KIRKLEES METROPOLITAN COUNCIL INVESTMENT & REGENERATION SERVICE

DELEGATED DECISION TO DETERMINE PLANNING APPLICATIONS

Reference No:	2021/62/94270/W
Site Address:	231, Fleminghouse Lane, Almondbury, Huddersfield, HD5 8TY
Description:	Erection of hip to gable front extension, side dormers, single storey canopy to front elevation and rear balcony and associated exterior alterations
Recommending Officer:	Tom Hunt

Officer Report

Description
ELEVATIONS AS PROPOSED

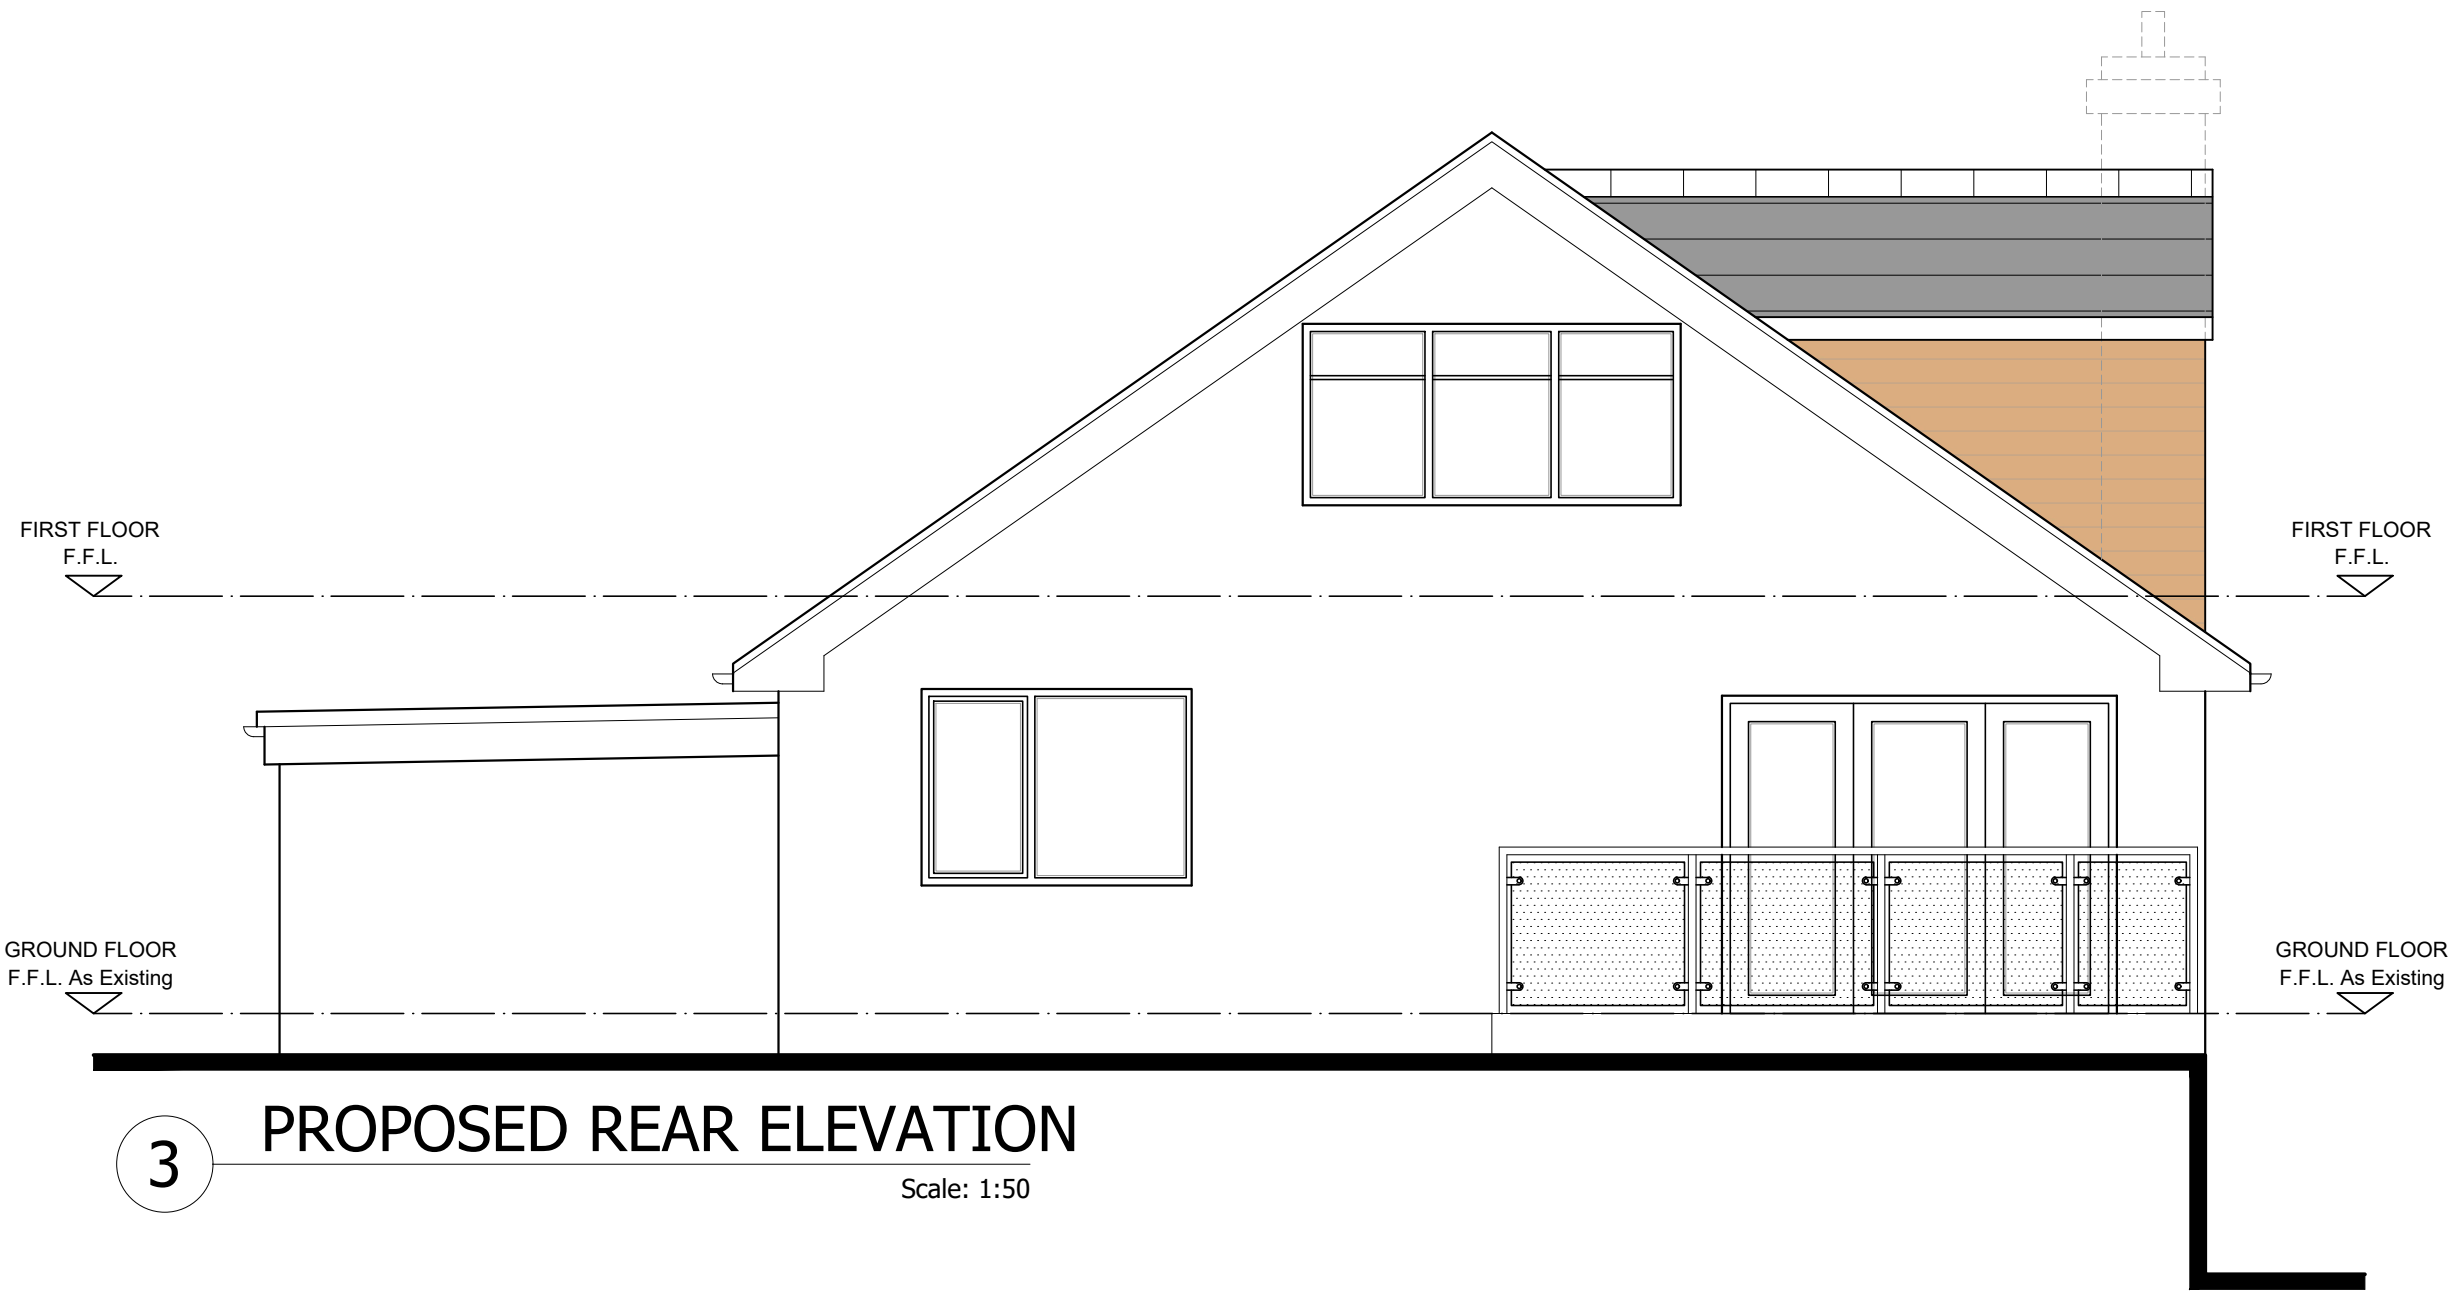
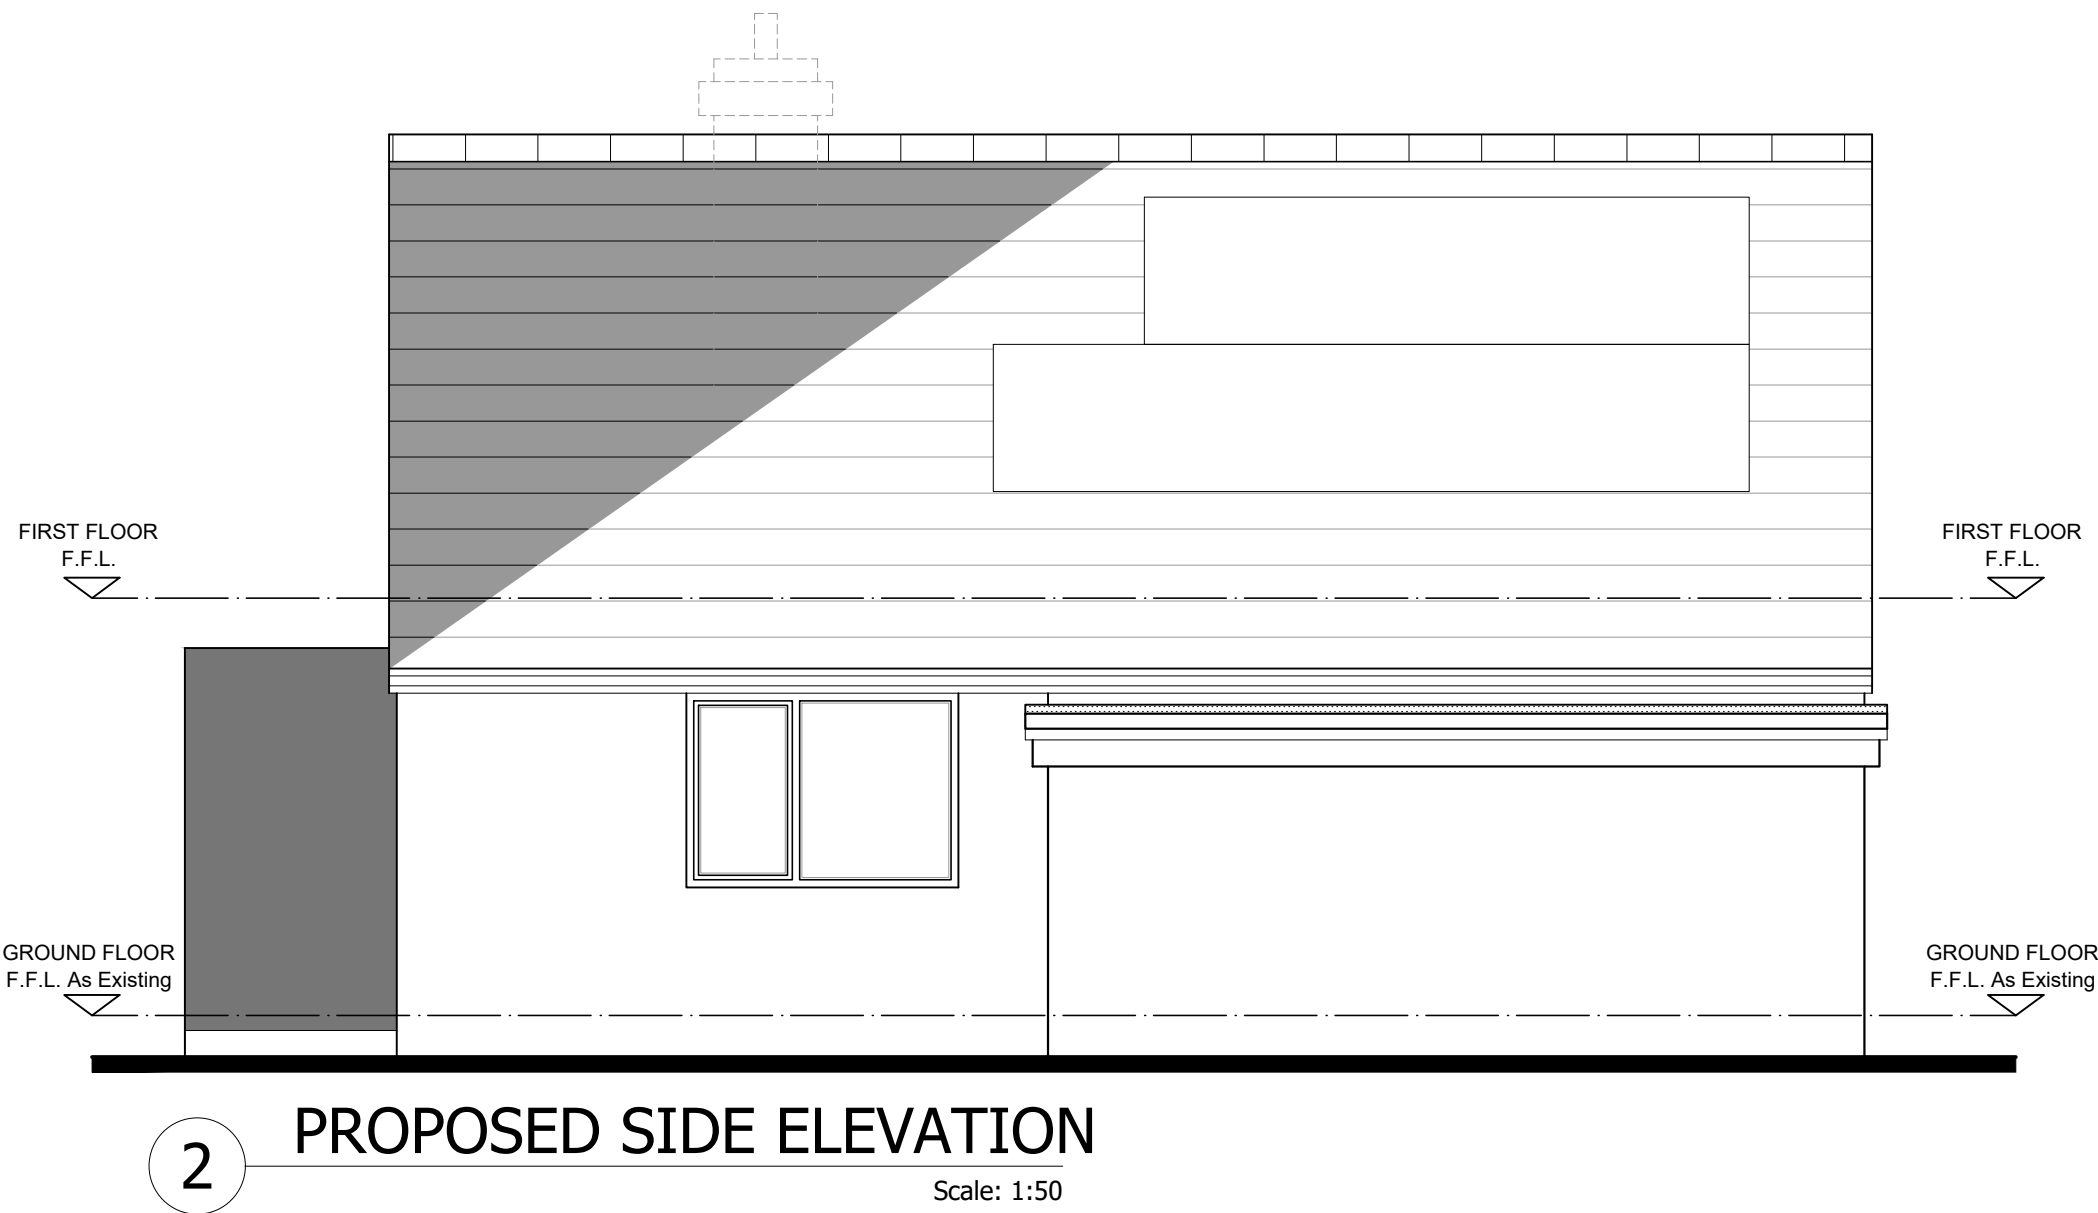
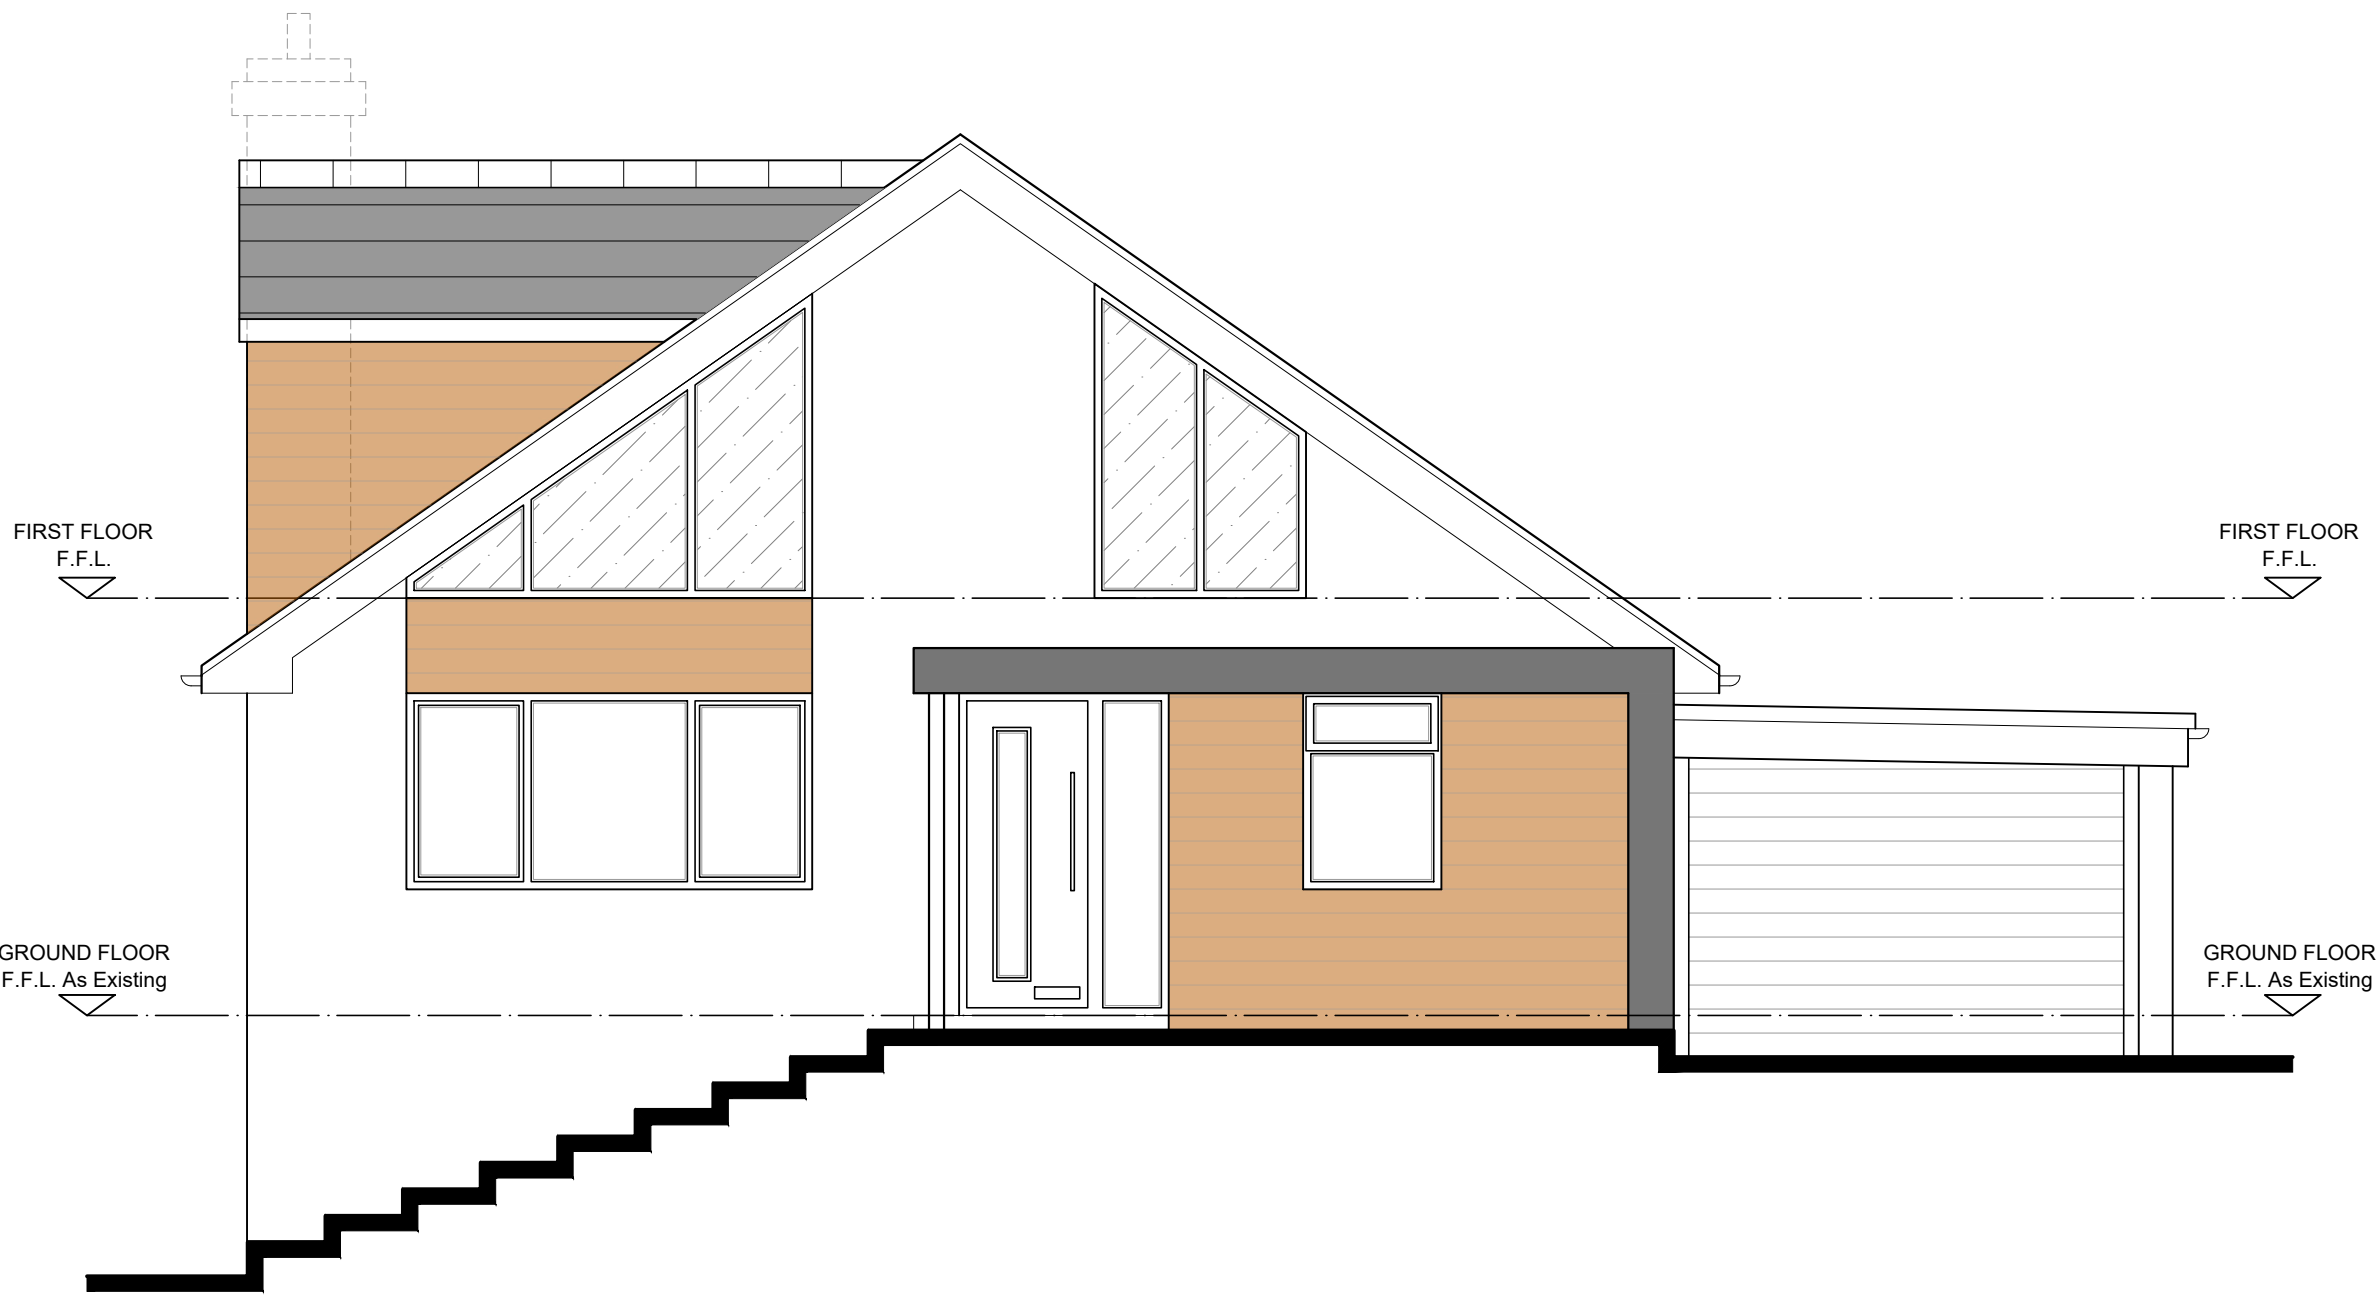
In addition, Principle 1 – Local character and street scene, Principle 2 – Impact on the original house, Principle 7 – Outdoor space and Principle 8 – Energy efficiency, of the 'House Extension and Alterations SPD' is relevant. The proposal would have a hipped to gable end roof extension which would add some additional bulk to the primary elevation however its set back in relation to the highway and its matching concrete tile roof similar pitched to

existing roof would aid it in harmonising with its host building. There would be gable end windows to the roof space facing the highway and the PROW which would be of a contemporary design not seen in the streetscene, however these are relatively small openings which follow an existing opening on one side and are considered to be acceptable. The addition of natural cedar cladding material in sections would add a warm natural tone to the primary elevation and aid in breaking up the render along with the added glazed sections so the render does not overly dominate visually into the streetscene. It is noted that the use of render is a material used in the streetscene and also on the Listed Building. The canopy would be dark grey metal and have its profile be of contemporary design which would contrast subtly with the cedar and render to provide a similarly colour material palette to the roof tile colour aiding in harmonising it within the plot and streetscene while evolving the design.

The proposed three side dormers while being of limited width individually, collectively they would occupy the majority of the roof on the side of the property and would add bulk and massing to one side of the host. It is acknowledged that the use of pitched roof side dormers is not a common feature within the streetscene, however the steepness of the highway with the graduated plot ground levels as the slope ascends, would help aid the side dormers to be integrated in the streetscene and to add some varied visual interest to an otherwise blank roof elevation.

The varying widths of the dormers would not be very discernible given the slightly skewed perspectives of the steep hill's highway and its dwellinghouses at different ground elevations.. On balance the side dormers would be viewed as acceptable given the streetscene's variation in architectural styles, roof forms and its topography.

This property is at a significantly lower ground level position in relation to the elevated No. 231. Its side window set close to its roof ridge height indirectly faces the opposite part of No. 231's existing side elevation window, the proposed side dormers would effectively overlook above the side window and look out on its roof with no rooflights. In addition, it has a ground level side window facing a section of No. 231's blank side elevation and the plot's retaining wall and part of the side elevation of its bay window to its primary elevation which faces the raised front garden plot of No. 231. However to ensue that there is no potential for a detrimental impact occurring the windows on the dormer will be conditioned to be obscure glazed. The added bulk and massing of the side dormers and the hip to gable extension to the south of the property aided by the ground level changes would be visually broken up with no views in or out from the No. 229's roof to contribute towards detrimental overbearing or overlooking impact. The side elevation window to ground and the narrow section of the side elevation of its bay window facing the property would have no additional overlooking or overbearing impact.

3. The external west elevation wall and roofing material of the hip to gable extension and the external north elevation 'faces' of the three side dormer and its roofing material hereby approved shall in all respects match those used in the construction of the existing building.

4. The development shall not be occupied until the 3 windows which serve an ensuite, bathroom and bedroom 2 on the northern elevation of the dormer window extensions hereby approved has been fitted with obscure glazing, minimum grade 4. Notwithstanding the provisions of section 55(2)(a)(ii) of the Town and Country Planning Act 1990 and the Town and Country Planning (General Permitted Development) Order 2015 (or any Order revoking or re-enacting that Order with or without modification) the window shall thereafter be so retained obscure glazed.
